**WEST SUSSEX COUNTY COUNCIL
PLANNING SERVICES CONSULTATION**

SUBJECT: LU/280/17/PL - Conversion of existing building to form 5 No. dwellings with associated cycle & refuse stores, parking & landscaping with dormers to north & south elevations.

General Henrys, 31 Horsham Road, Littlehampton, BN17 6BZ

Proposed Conversion Site Plan

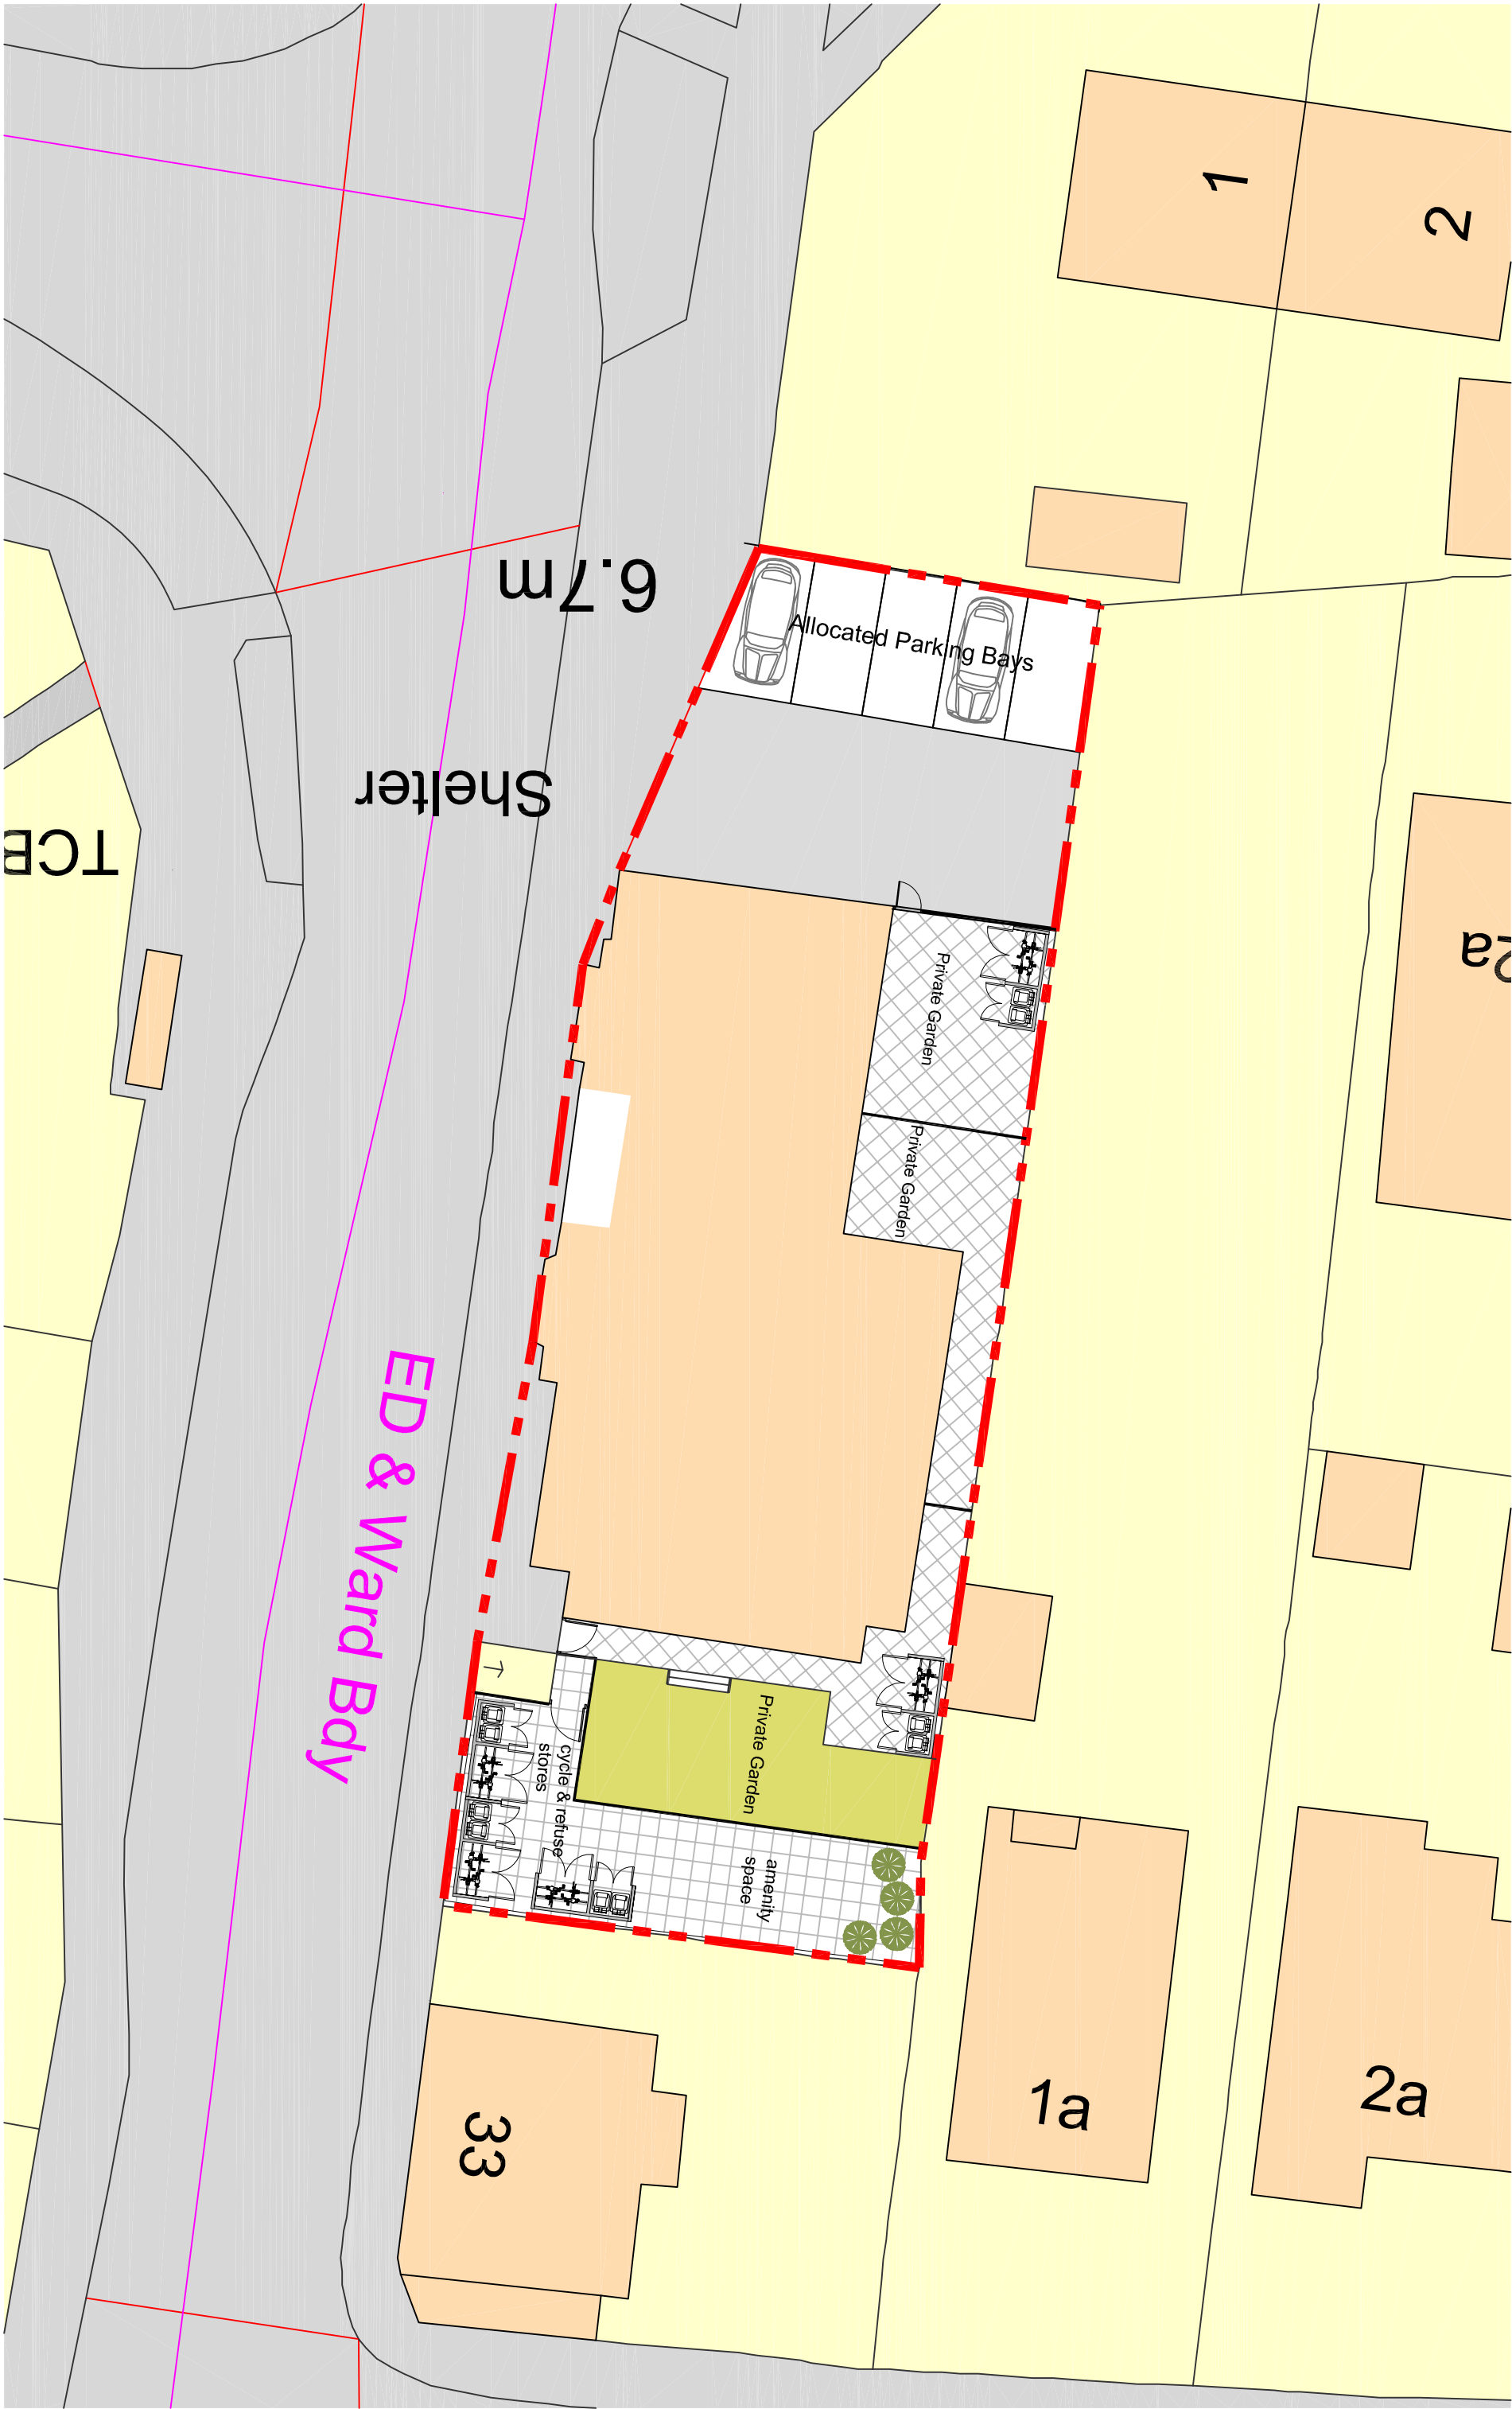
The furthest east car parking bay does not meet the required dimensions of 2.4m by 4.8m to be counted toward parking provision without the space overhanging the highway. The proposals have therefore been assessed on the basis of 4 x car parking bays being provided. These should be amended to show that they will be of an unallocated arrangement. On the basis of the parking provision being unallocated a total demand for four spaces is envisioned by the WSCC Car Parking Demand Calculator. Any additional and overspill parking could not occur in locations that would be deemed detrimental to highway safety due to the double yellow lines protecting the nearby road network in vicinity to the mini-roundabout.

An inspection of the 'Proposed Conversion Plan' shows that 6m space rear of the car parking spaces is available in order that a turn on site can be performed and cars can exit on to Horsham Road in a forward gear. Considering the relatively low scale parking and vehicle movements anticipated the LHA would not raise an objection to the proposed parking and turning arrangements within the existing off-street car parking area.

In summary the LHA advise that the fifth car parking space be omitted from the scheme as it is not sufficient dimensions to count toward parking provision. The remaining four spaces should operate on a first come first serve basis.
